**From:** Ellie Myers  
**Sent:** Monday, October 6, 2025 10:37 AM  
**To:** Ellie Myers; Dan Suggs; Josh Pozzobon; mcn.ellensburg@gmail.com  
**Cc:** dwschwartz@gmail.com; Eliana West  
**Subject:** FW: Built - Septic Layout and Site Plan for 1151 Wapiti Dr  
**Attachments:** email.pdf; CleElum\_SitePlan\_8.29.2025.pdf

**From:** Ian Garrity <ian@builtprefab.com>  
**Sent:** Monday, October 6, 2025 10:19 AM  
**To:** Ellie Myers <ellie.myers@co.kittitas.wa.us>; Dan Suggs <dan.suggs@co.kittitas.wa.us>; Josh Pozzobon <josh@builtprefab.com>; mcn.ellensburg@gmail.com  
**Cc:** dwschwartz@gmail.com; Eliana West <wendy9817@gmail.com>  
**Subject:** Built - Septic Layout and Site Plan for 1151 Wapiti Dr

# SITE PLAN - NEW SEPTIC

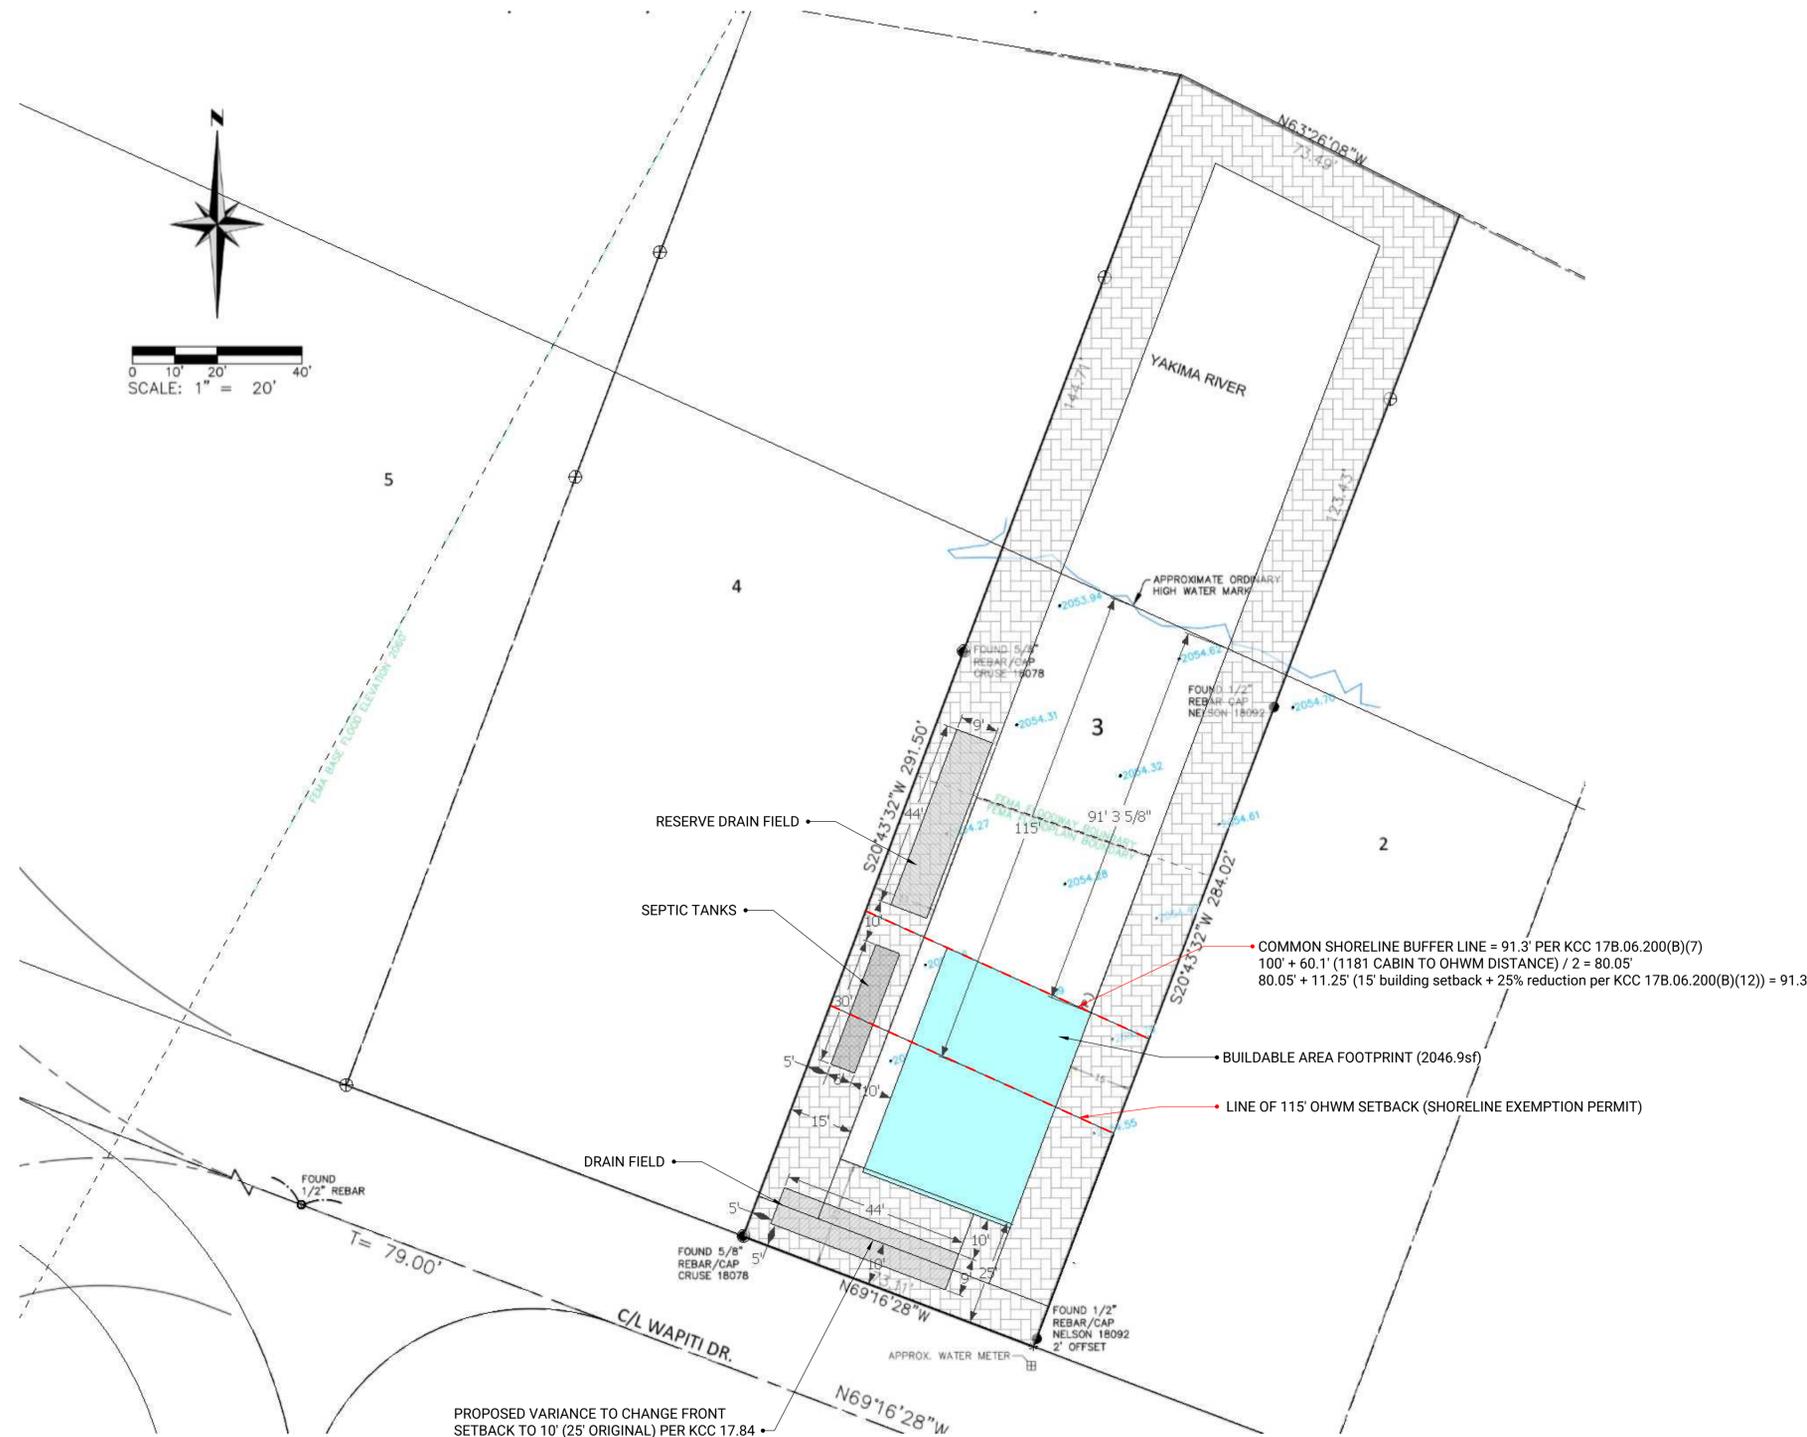
This allows the primary septic lines to be contained within a much smaller area (something like 9x44 @ Jarawan) and located as they are proposed currently at the streetside.  
The septic tanks would remain located as they are currently, along the west property line.  
The backup lines would now be located beyond the tanks along the west property line (assuming also 9x44 area).

SITE PLAN

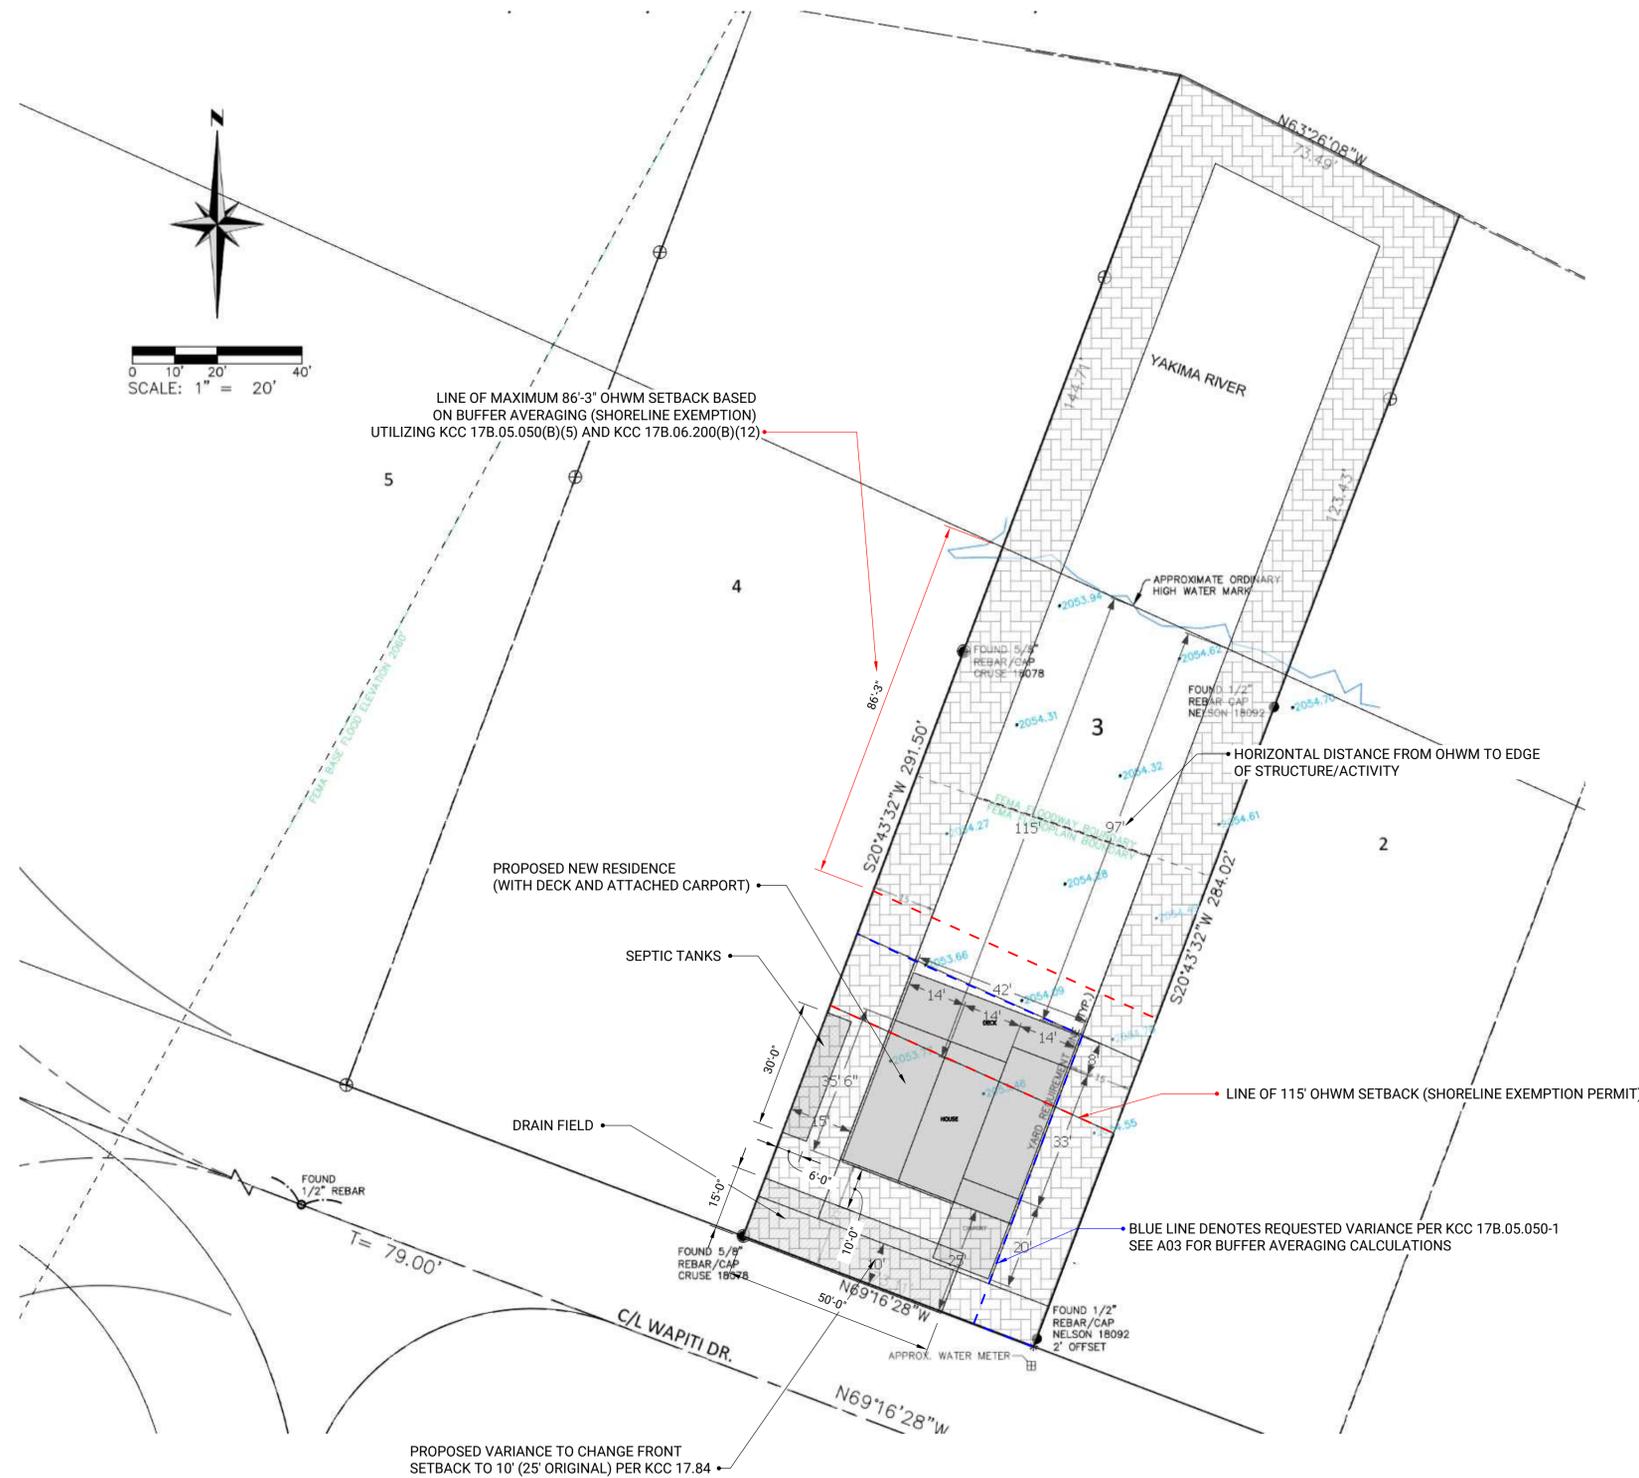
After speaking with Ellie and Dan last week, the backup septic lines may be placed within the Shoreline Buffer area (email attached).

**Mark** - for discussion, but we would need the septic application/site plan updated accordingly and provided to Dan.
